ALDINGBOURNE PARISH COUNCIL

08 January 2014

Re: Planning Application: AL/95/13 - Outline planning application for 3 no. detached houses with garaging at land west of Oaktrees, Fontwell Avenue - This is a Departure from the Development Plan

Drawing Name
Site Layout Plan

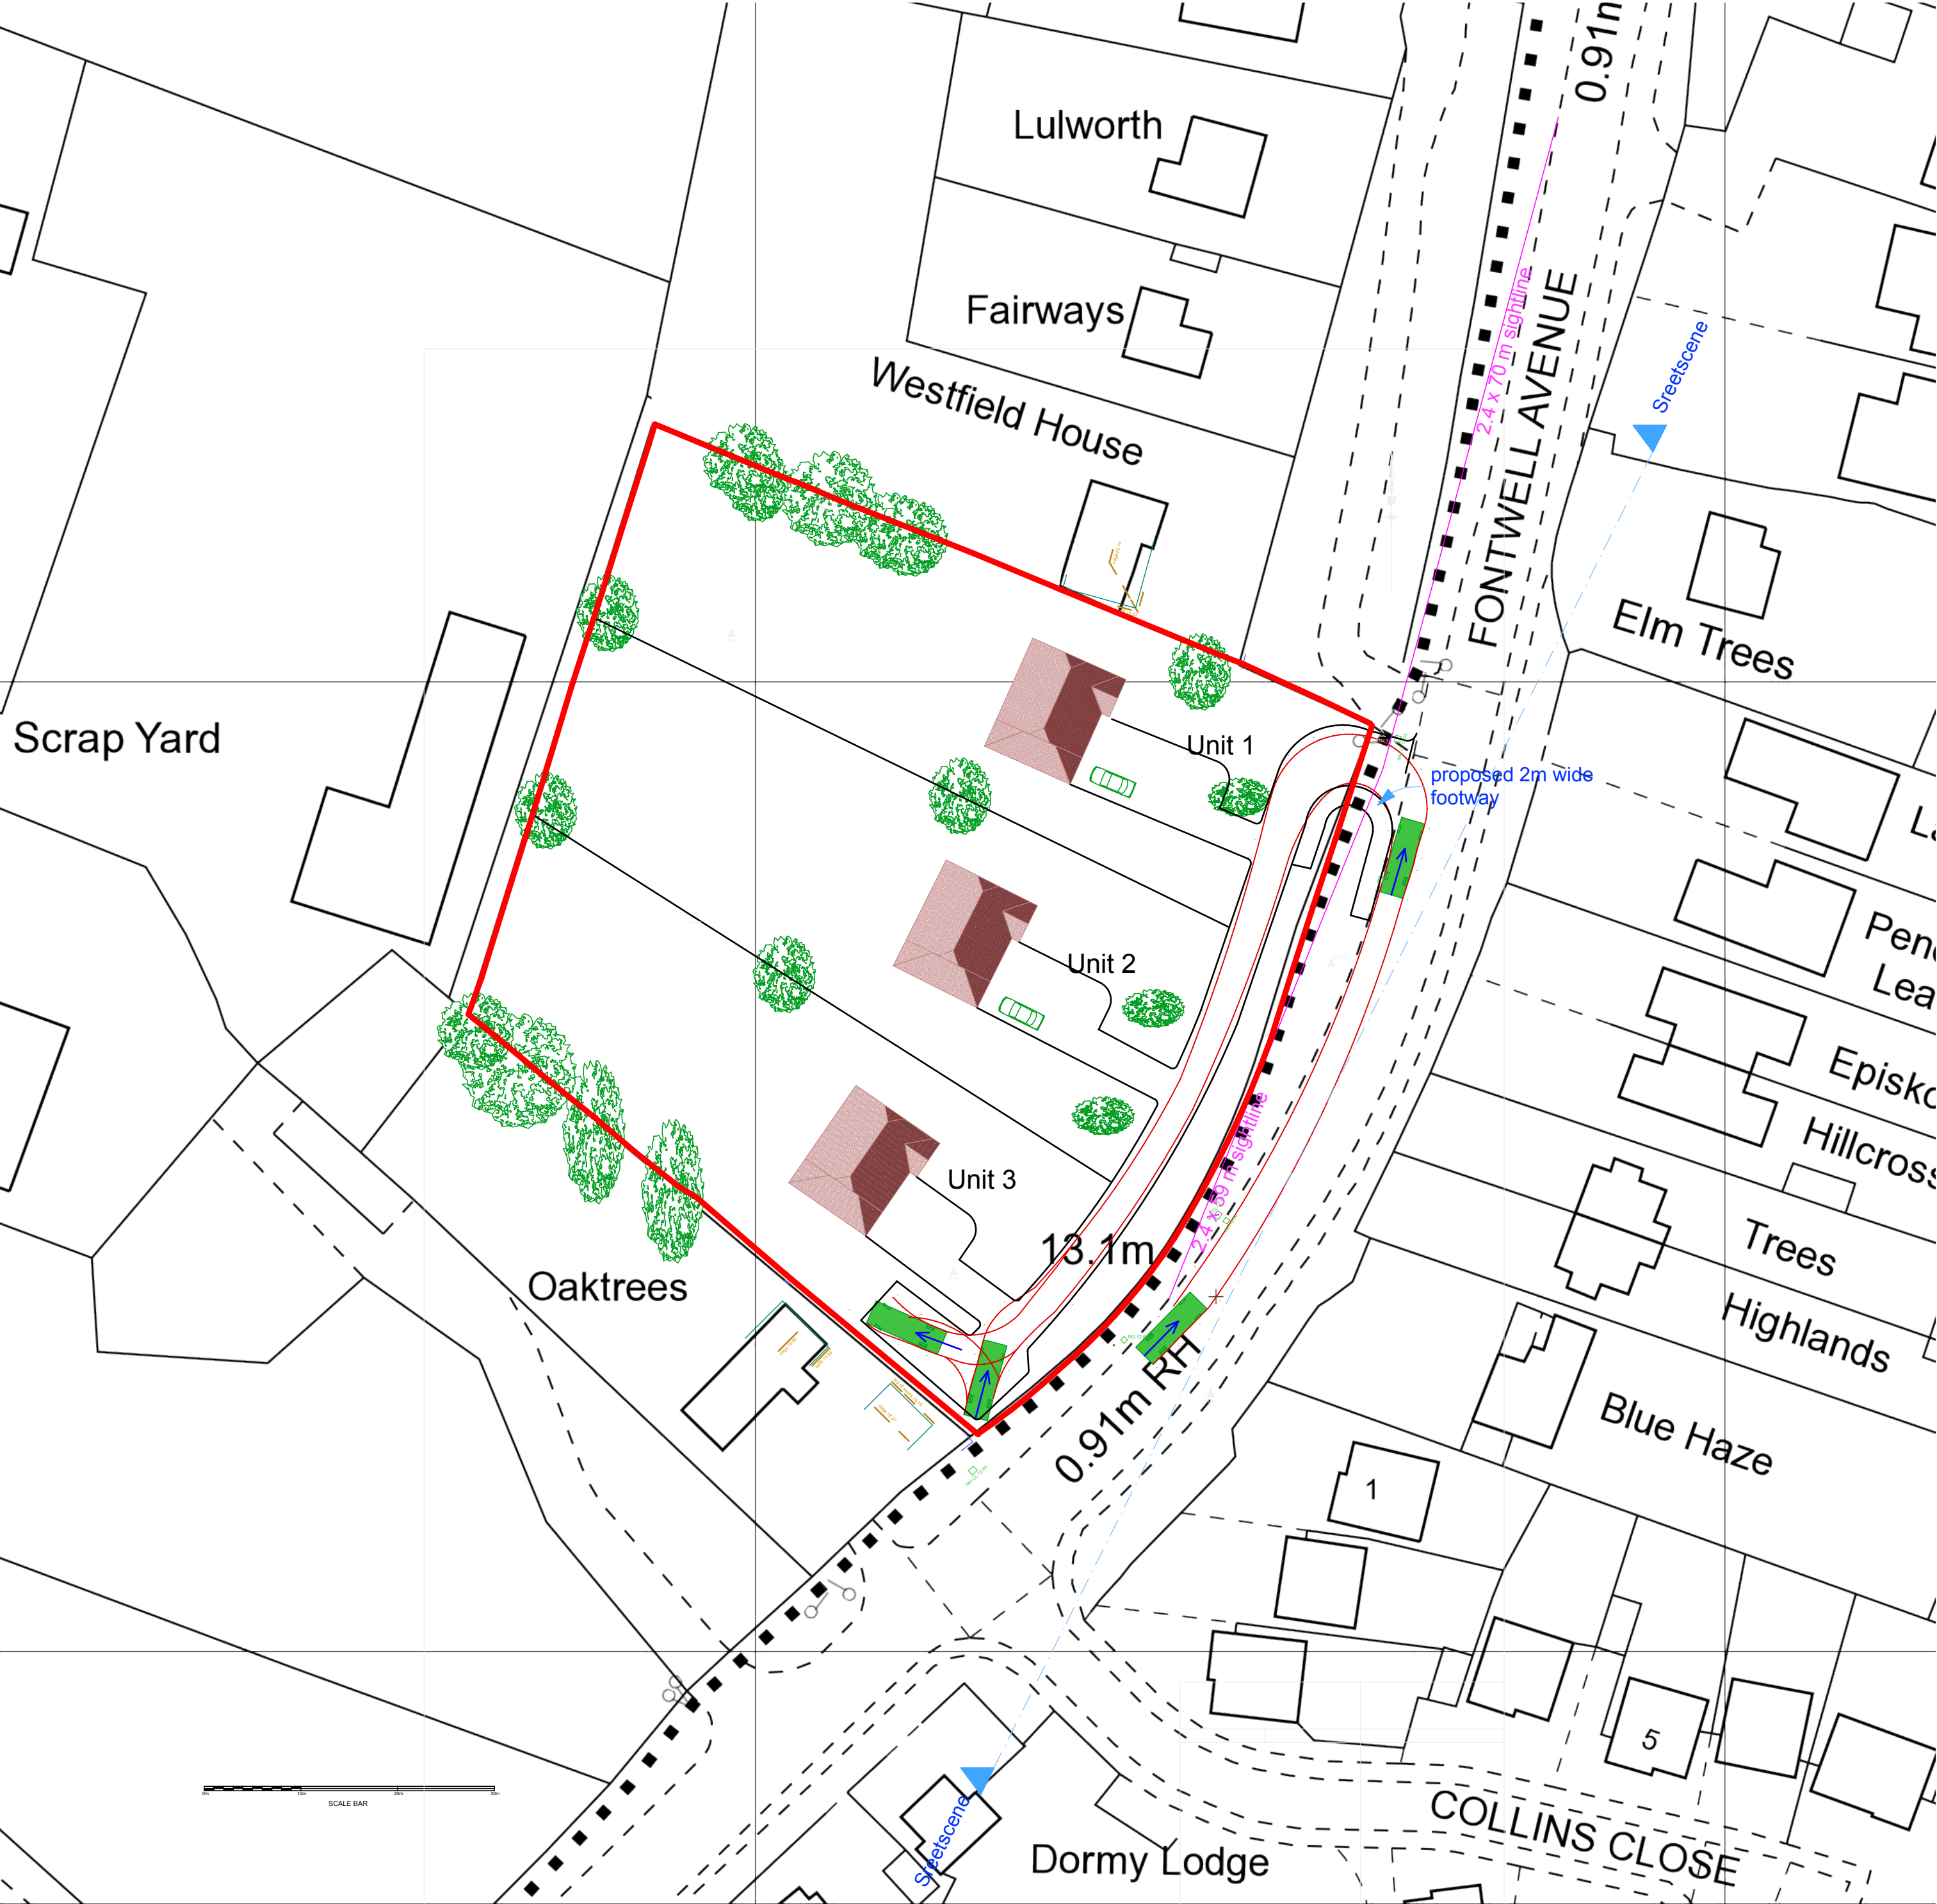
1. The proposal is for 3no. detached houses with associated garaging. The dwellings are widely spaced to reflect the existing street scene and density of development on the west side of Fontwell Avenue. The Parish Council believes that the site can be utilised more efficiently and is capable of offering a more diverse housing mix to meet local demand. The indicative street scene submitted as part of the application would suggest that the 3/4 bed dwellings could be moved closer together to give a more continuous built edge allowing a pair of smaller bed semi-detached properties at one end. Due to the proximity and activity of the nearby scrap yard and workshops directly behind the site, to the west, the provision for a single row of dwellings fronting Fontwell Avenue is considered appropriate.

2. The northern site access appears awkward with a sharp turn into the site and should be reviewed by the local highway authority. It is noted that the visibility splay at the site entrance will result in substantial removal of the existing vegetation / hedgerow along the frontage of Fontwell Avenue. It is considered that a suitable landscape scheme of native trees and hedgerow shrubs should be implemented in the land between the internal estate road and Fontwell Avenue to replace existing vegetation to be removed, provide appropriate screening and maintain a rural edge to Fontwell Avenue.

3. Consideration should be given to extend the footpath at the northern site entrance southward along Fontwell Avenue for the length of the site to provide greater potential for pedestrian access to local shops and services at Eastergate Square. It is acknowledged that the current grass verge is quite narrow, however as much of the existing vegetation will need to be removed due to the visibility splay there is potential to install a footpath and provide replacement planting further into the site.
